From: Amanda Scholes on behalf of Planning.Responses
Sent: 31 August 2018 08:37
To: Planning Scanning
Subject: FW: Objection to Application AW/218/18/HH
Attachments: let.Objection to Plan Application AW-218-18-HH.docx

**Planning Objection sent by Email on 27th August 2018
Application Ref: AW/218/18/HH**

OUTBUILDING DRAWING
LAYOUT PLAN
11 ST RICHARDS WAY
PO21 3BD C. NEWSON

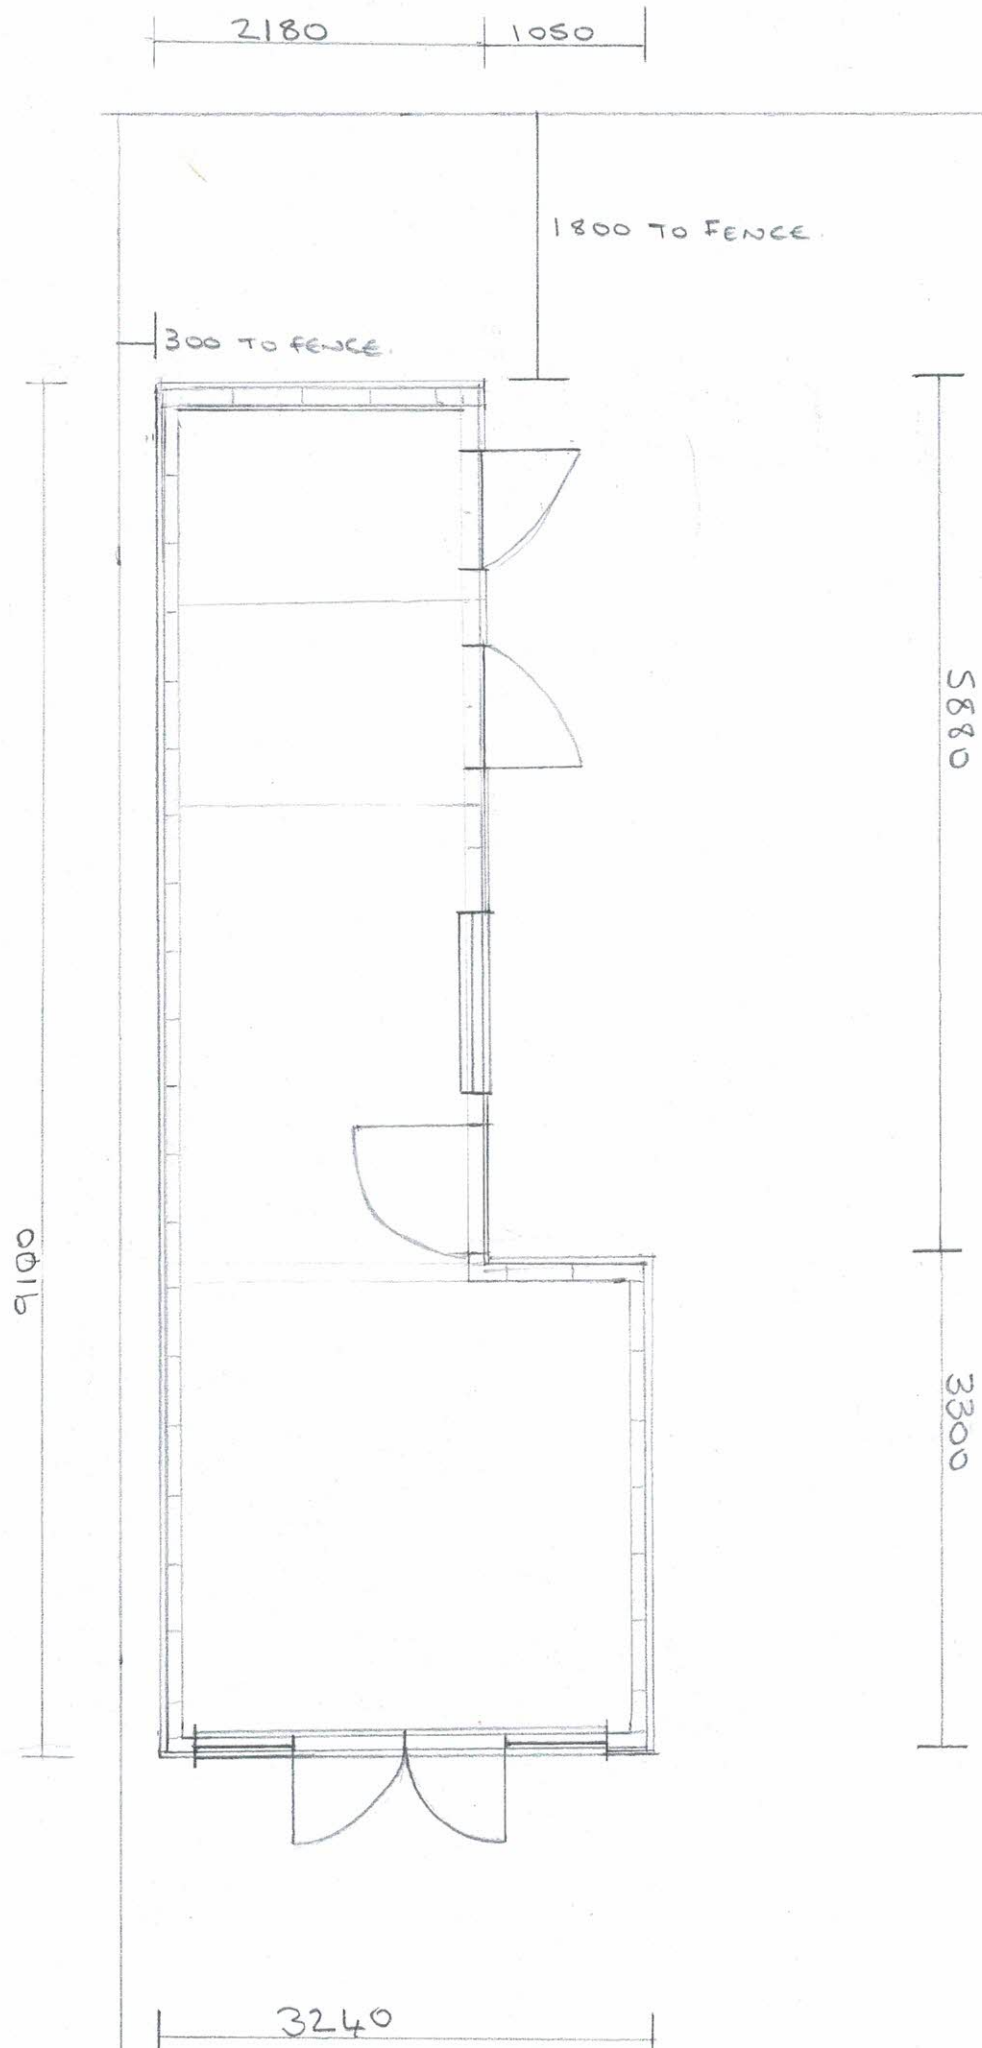
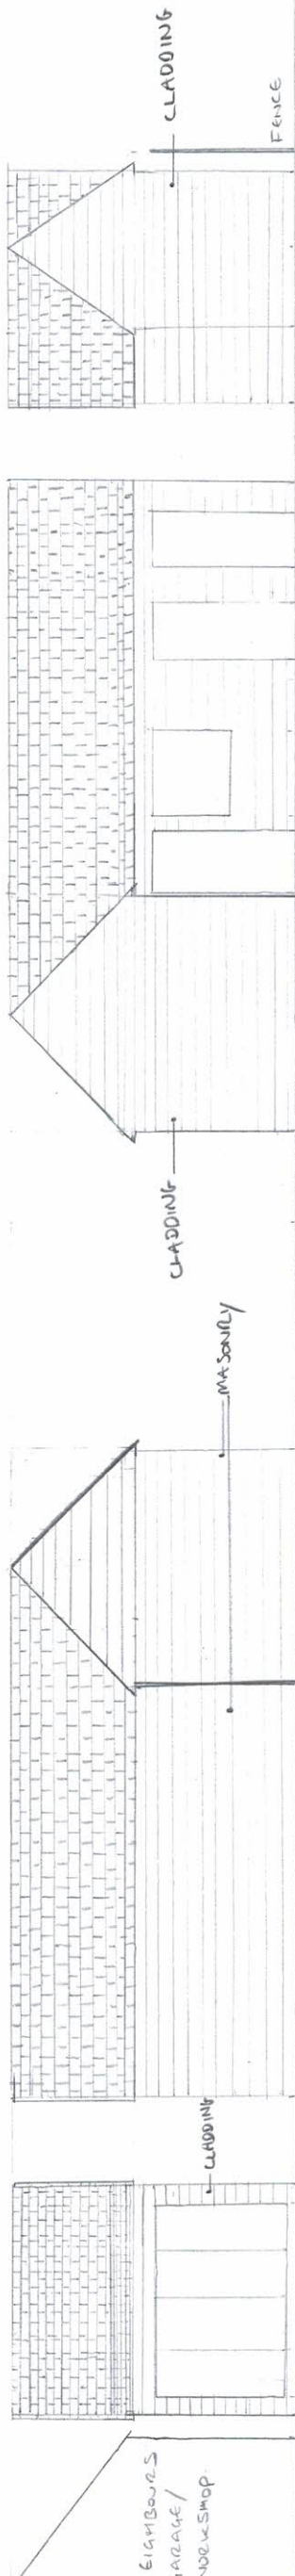
Whilst it does not immediately impact on us we are concerned as the development as proposed and indeed started does not allow the neighbour to maintain his building or for access to clear the guttering. You will see from the photo below that the new development, over 9 metres long sits very close to the boundary (with supposedly only a 30cm gap) and does not enable anyone to get to maintain or paint the wall which is currently painted and will continue to need occasional attention. Equally it will be impossible over a 9 metre length to get along to clear the gutter and we are in an area with many trees that mean leaves congregate in the gutters and they need regular- possibly annual – clearing.

We also feel the location so close to the neighbours building (and unnecessarily close as there is plenty of width to the garden) means that appropriate maintenance will not be possible; hence the building should be moved possibly half a metre away from the side boundary.

OUTBUILDING DRAWING 02
ELEVATIONS DRAWING
11 ST. RICHMOND WAY, PO21 3BD
C. JENNISON.

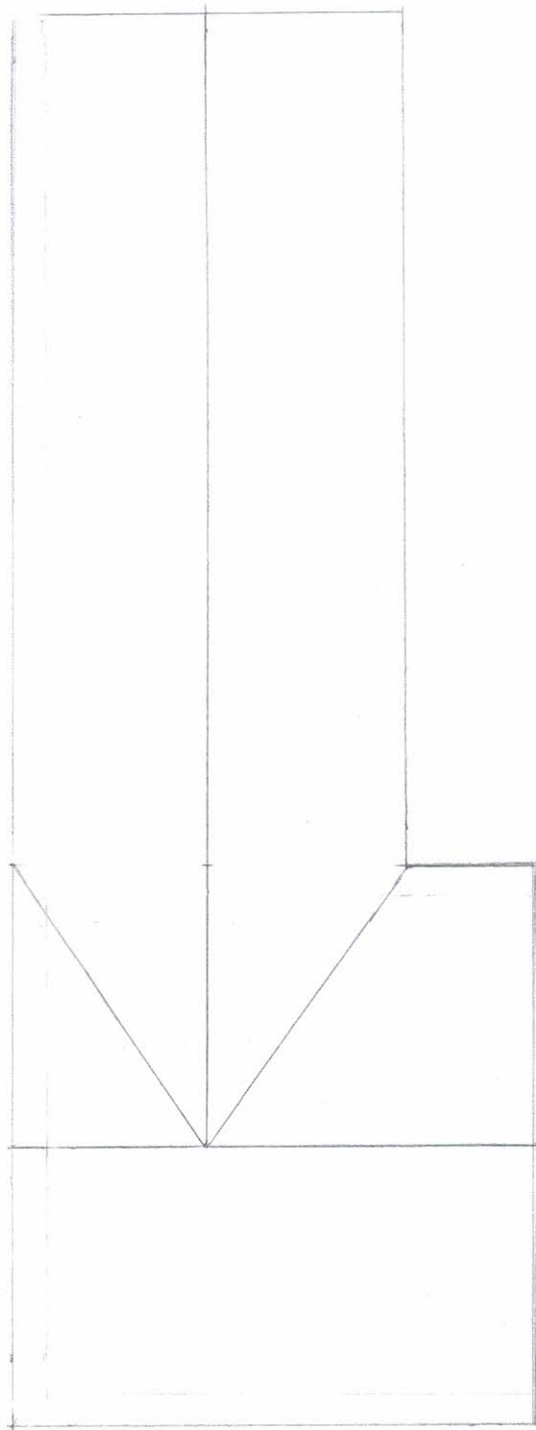
We wish to object on two counts to the above application. We note that if the proposal had been built with a lower roof ridge (less than 2.5 metres above ground) then as we read the guidance from the government Planning Portal it may not have needed a planning consent. The ridge is however very significantly higher at 4 metres and we consider unnecessarily so and does considerable harm to us as neighbours.

Council to consider requiring the applicant to reduce the roof pitch to no more than 35°, thereby enabling them to use any standard tile on the roof but also limiting the light reducing impact on our home. This lower pitch would lift the ridge just within 77cm above the eaves and thereby reasonably limit the loss of light we would suffer from due to this development. It should be noted that the proposed development will hardly be visible at all from the applicant's home, located as it is in the far corner of a large garden and shielded from the house by extensive and mature shrubs forming a large hedge within the garden, yet whilst they do not see this development it would severely reduce the light available to the working area of our kitchen.
